Application No: EP/124/20/HH
Site Address: Little Dormers 23 Upper Drive East Preston BN16 1QN
Description of works: New bay and porch skirt roof to the front elevation, and roof linked detached double garage.

Objections to Planning Application: EP/124/20/HH - 23 Upper Drive, East Preston

Location Plan and Block Plan

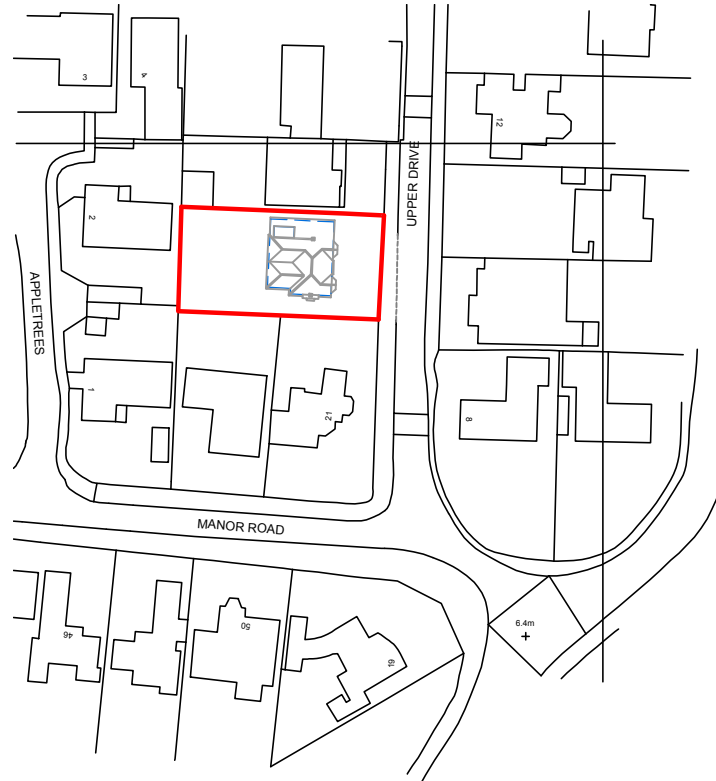
2) The location of this proposed structure extends way out beyond the building line which will severely impact the required sight lines when exiting onto Upper Drive. This could introduce a dangerous traffic situation.

Garage Plans and Elevations -
Proposed

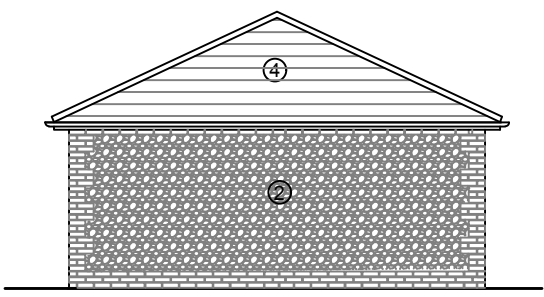
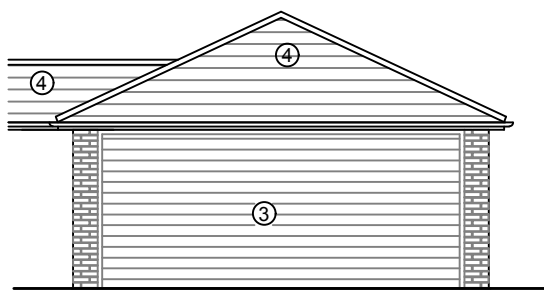
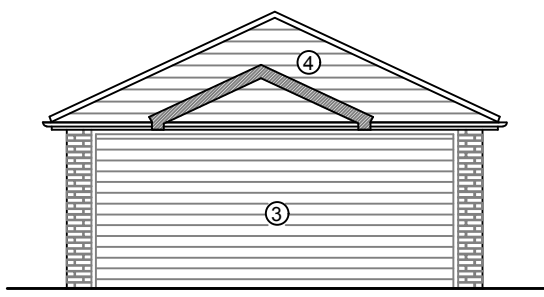
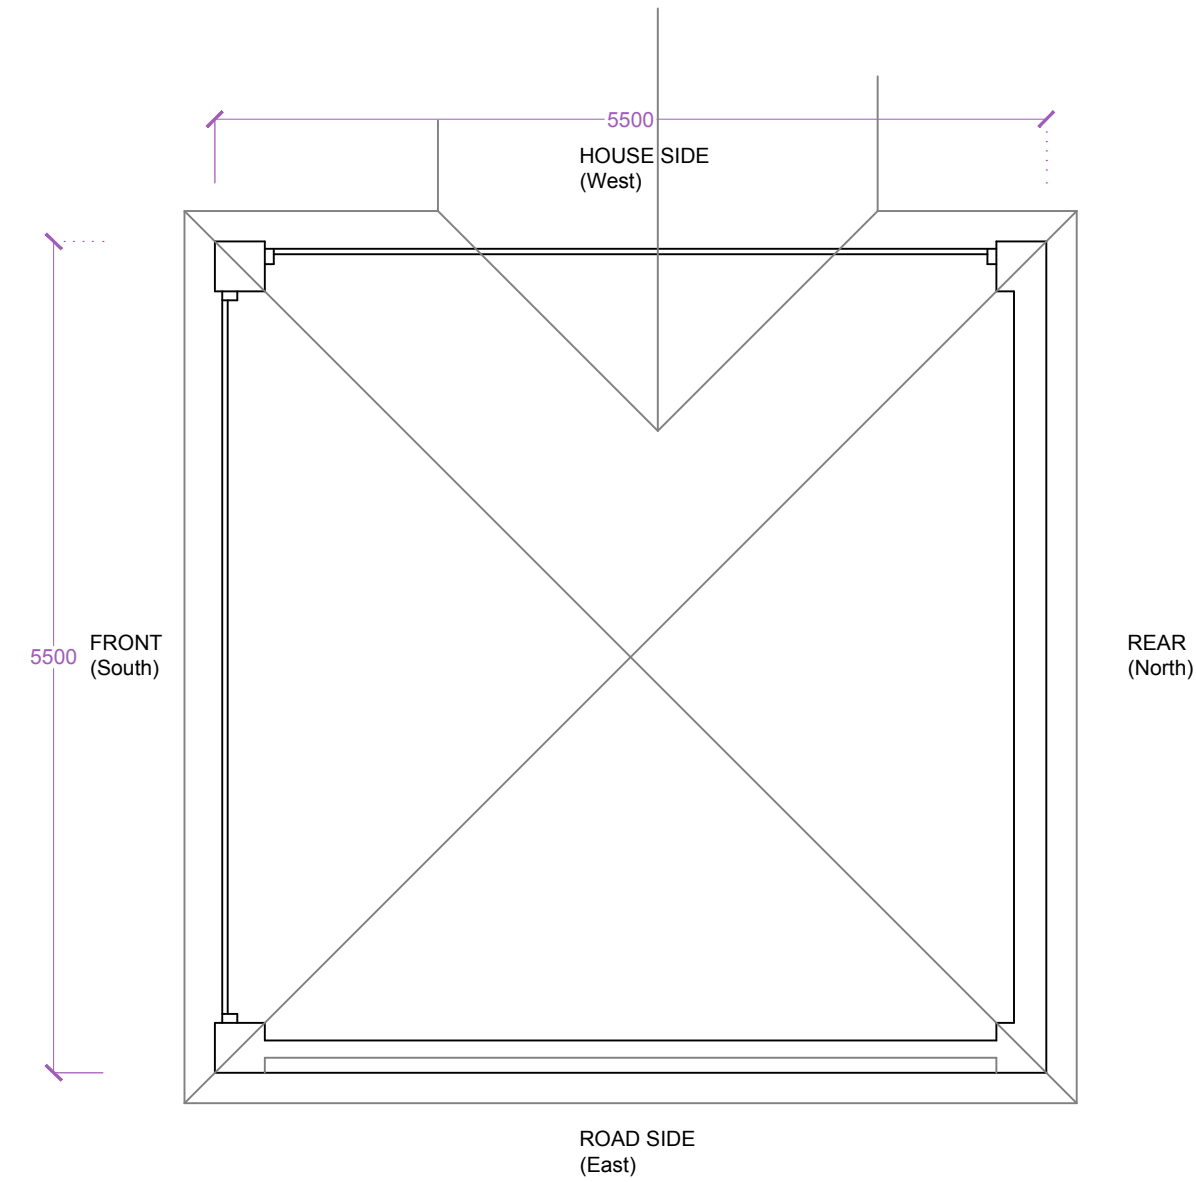
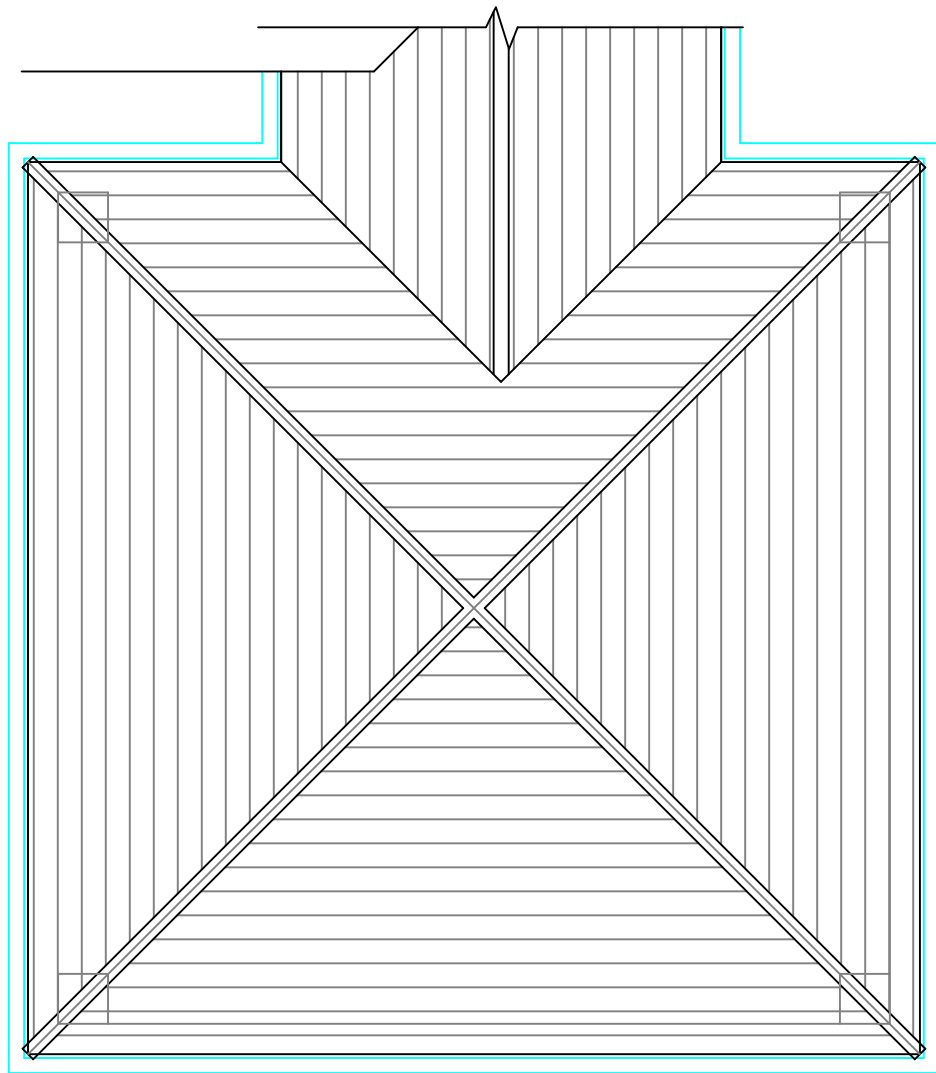
I wish to strongly object to the Garage element of the above Application primarily due to its sheer size and location.

1) The proposed structure is huge and totally out of keeping with the appearance and aesthetics of Upper Drive which current residents have taken care to observe and maintain.
In my view, a dangerous precedent would be set if this huge structure was allowed. This 5.5m x 5.5m x 3.67m high block is almost equivalent to an additional residential building which would have a dramatic, negative effect on the overall appearance of Upper Drive.

The plot is not large enough to accommodate a detached double garage let alone one of this size which is in addition to the integral garage already on the property.

4) The proposed garage is totally out of keeping with the visual appearance of Upper Drive and will have a dramatic effect on the Drive when viewed either from the South or North.

5) It will also have a negative effect on the daylight reaching No: 25.
